City of Portland, Maine - Building or Use Permit Application
389 Congress Street, 04101 Tel: (207) 874-8703, Fax: (207) 874-8716

Permit No: 02-0887 Issue Date: OCT 21 CBL: E-15-16
294 B019001 PAJ 910

Location of Construction: 19 Ardmore St	Owner Name: Gallant, Anthony	Owner Address: 19 Ardmore St	Phone: 2078261621
Business Name: n/a	Contractor Name: Anthony Gallant	Contractor Address: 244 Bancroft Street Portland	Phone: 2078261621
Lessee/Buyer's Name: n/a	Phone: n/a	Permit Type: Single Family	Zone: R-3

Past Use: Vacant	Proposed Use: New Single Family / 2,500 sq. ft. of living area with 22' x 22' attached 1 1/2 car garage and 23' x 6' covered porch.	Permit Fee: \$1,141.00	Cost of Work: \$150,000.00	CEO District: 1
---------------------	--	---------------------------	-------------------------------	--------------------

**PROJECT: GALLANT RESIDENCE**  
**DRAWING: FOUNDATION & ROOF PLAN**

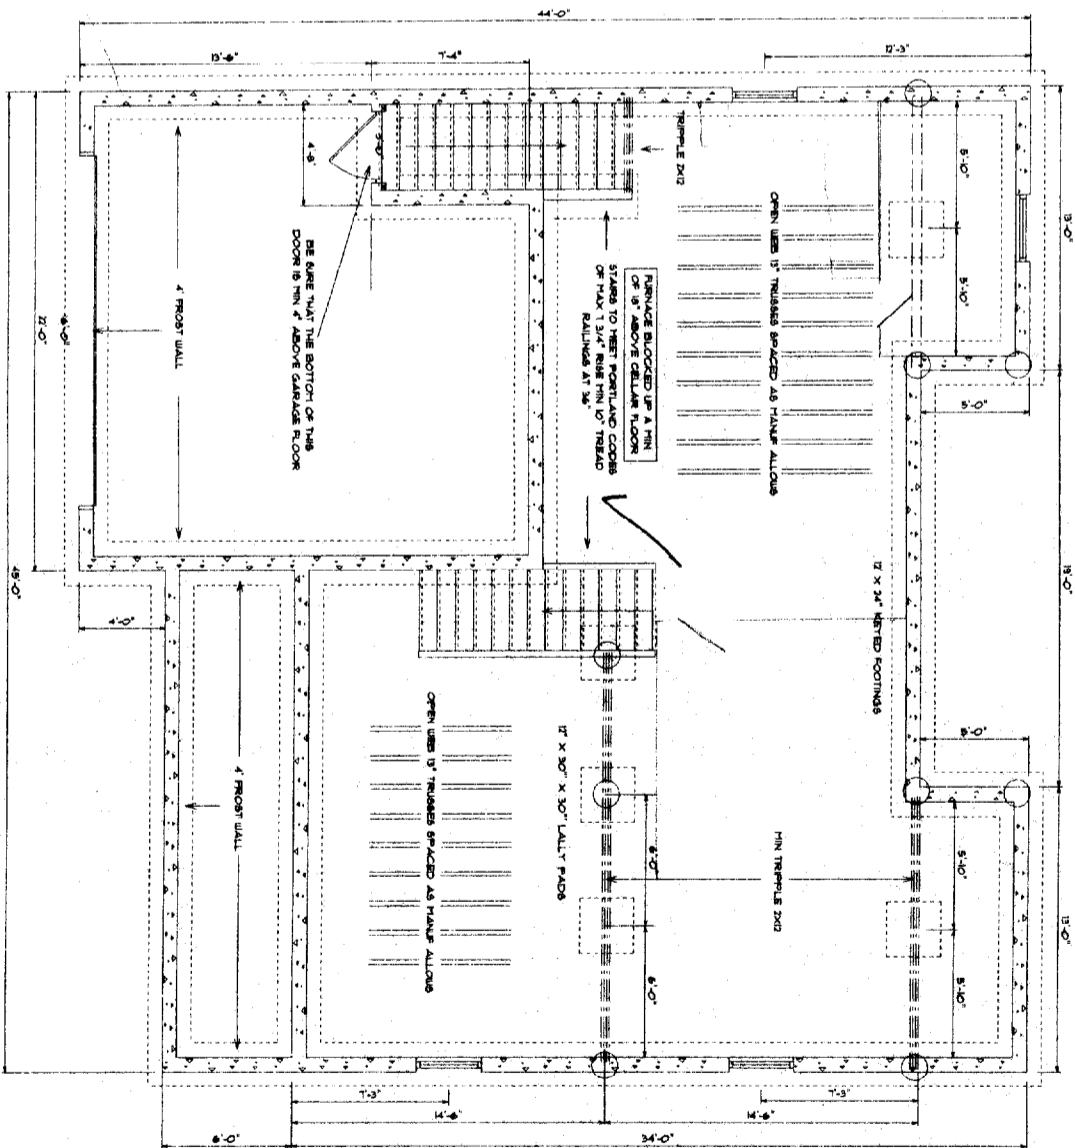
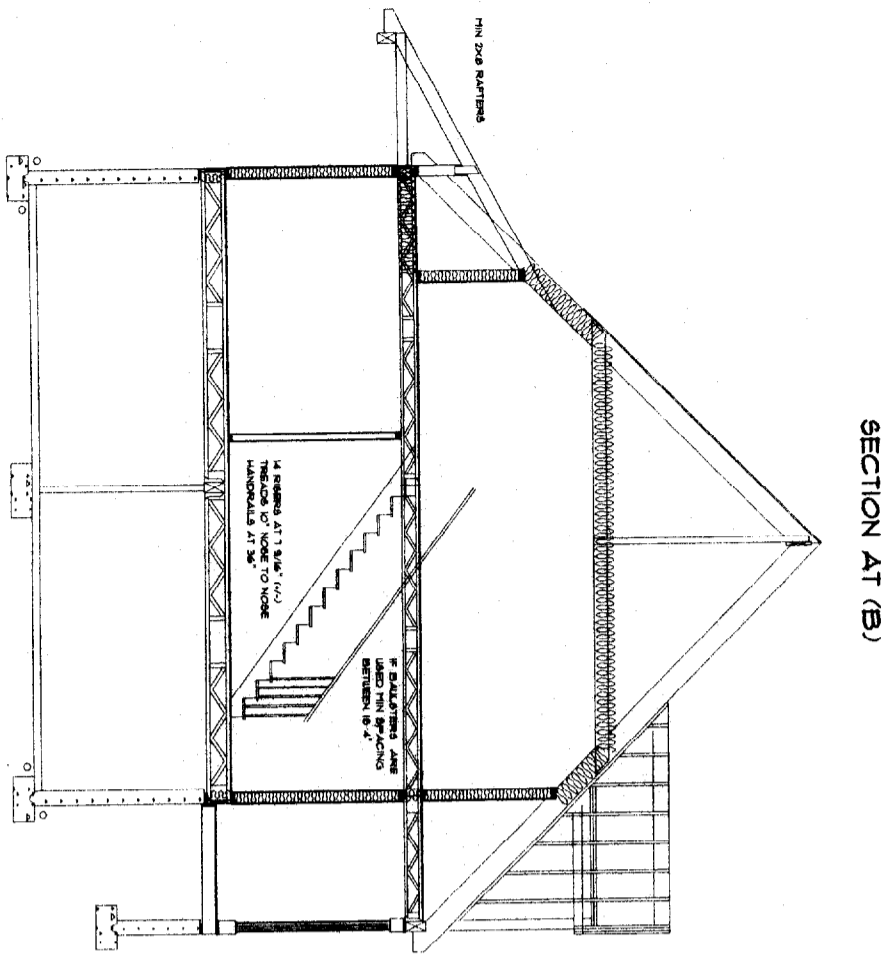
Comments: 19-23 Ardmore Street - shows 57 sq. Ft. Over the max lot coverage - also a question about the status of the unnamed side street- is it abandoned? This would affect the side setback (20' required instead of the 15.8'). Left message with owner. 8/19/02

It is understood by your revised plans that 1 foot is being taken off the front of the garage and that 1 foot is being taken off the full length of the rear of the building. By doing this reduction, this structure now meets the maximum lot coverage requirements within the R-3 residential zone.

This permit is being approved on the basis of the revised plans submitted on 8/20/02. Any deviations shall require a separate approval before starting that work.
